IN THE MATTER OF THE NATIONAL HIGHWAYS A66 NORTHERN TRANS-PENNINE PROJECT DEVELOPMENT CONSENT ORDER APPLICATION

AND IN THE MATTER OF LAND TO BE ACQUIRED PERMANENTLY AT SKIRSKILL HOUSE AND SURROUNDING PARK, PENRITH, CUMBRIA CA11 0DH

CAH2 " COMPULSORY PURCHASE HEARING

STATEMENT OF CASE OF

Drawing Title
**Special Category Land Plans
Regulation 5(2)(i)
Sheet 1 of 2**

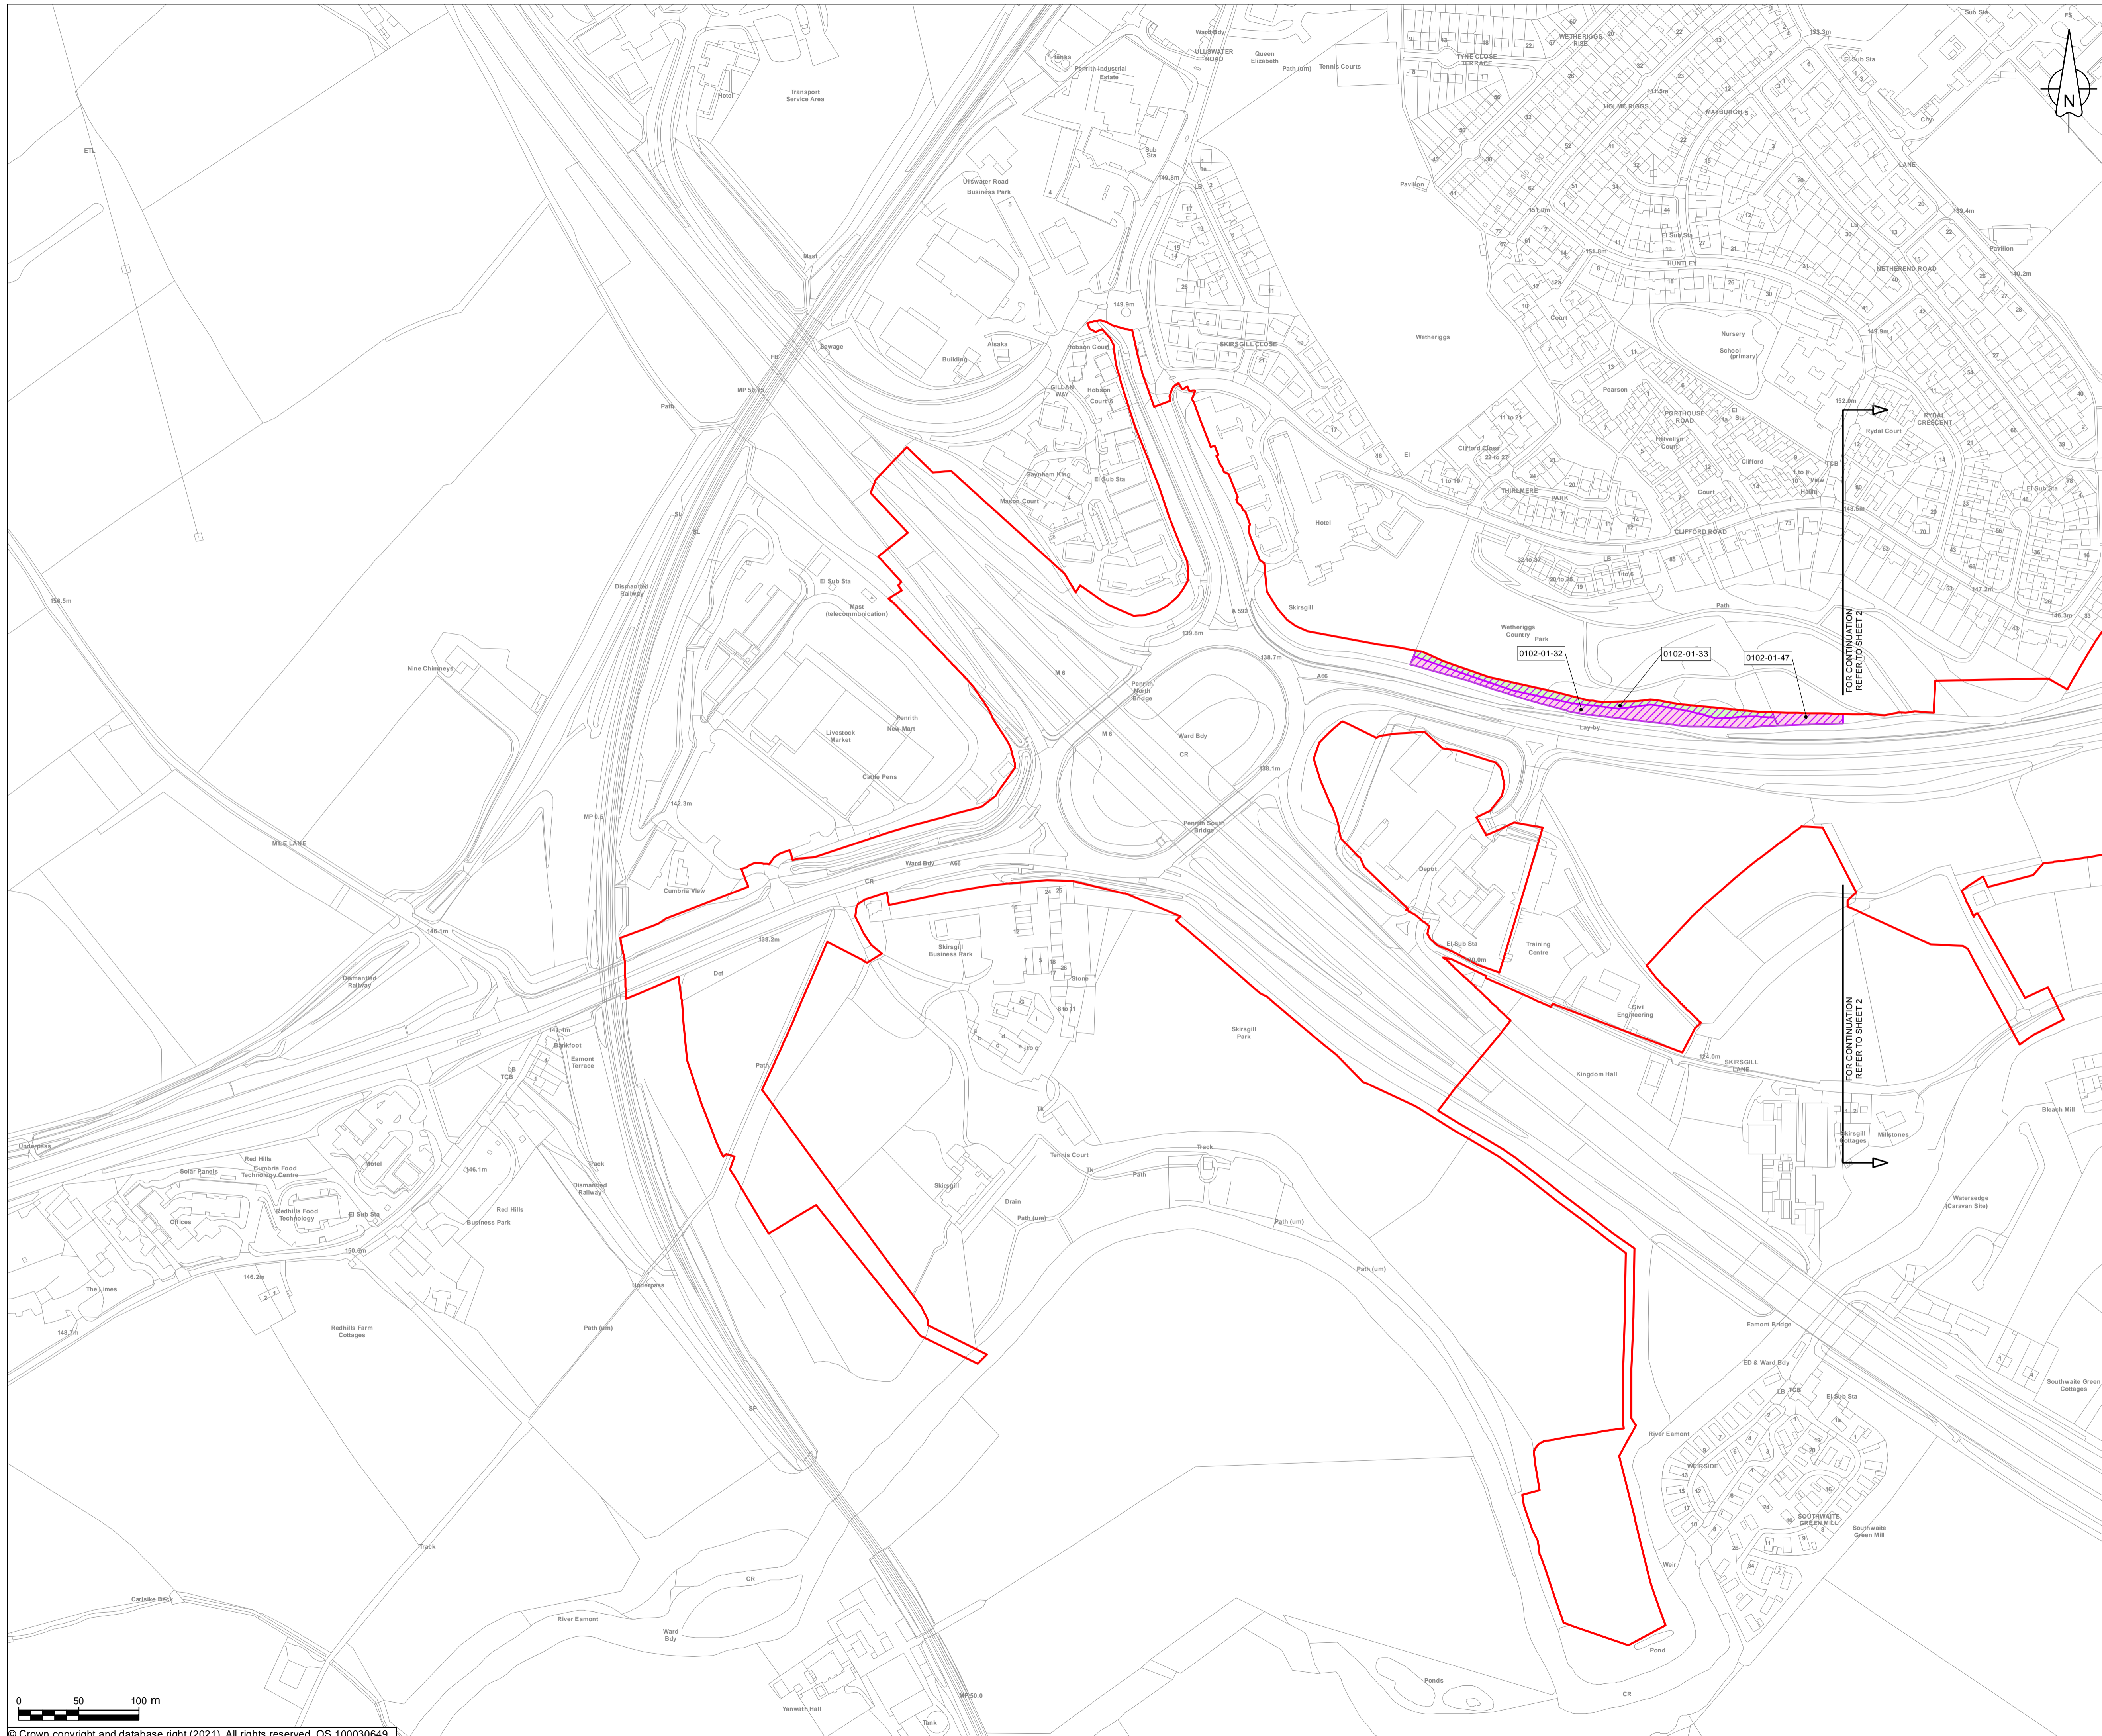
9. Fourth, it is understood that in the absence of any significant increase hard surfaced area on this section of the road, as a consequence of this proposed variation the attenuation pond is not needed the existing drainage being more than adequate, and the affected land (plot Nos 01020-01-06: 0102-01-07: 0102-01-50)can be removed from CA.

10. Fifth the Applicant has an existing permanent drainage easements with the Affected Persons Estate which are adequate of its purpose and no adequate engineering design has been table in justification for the proposed CA.
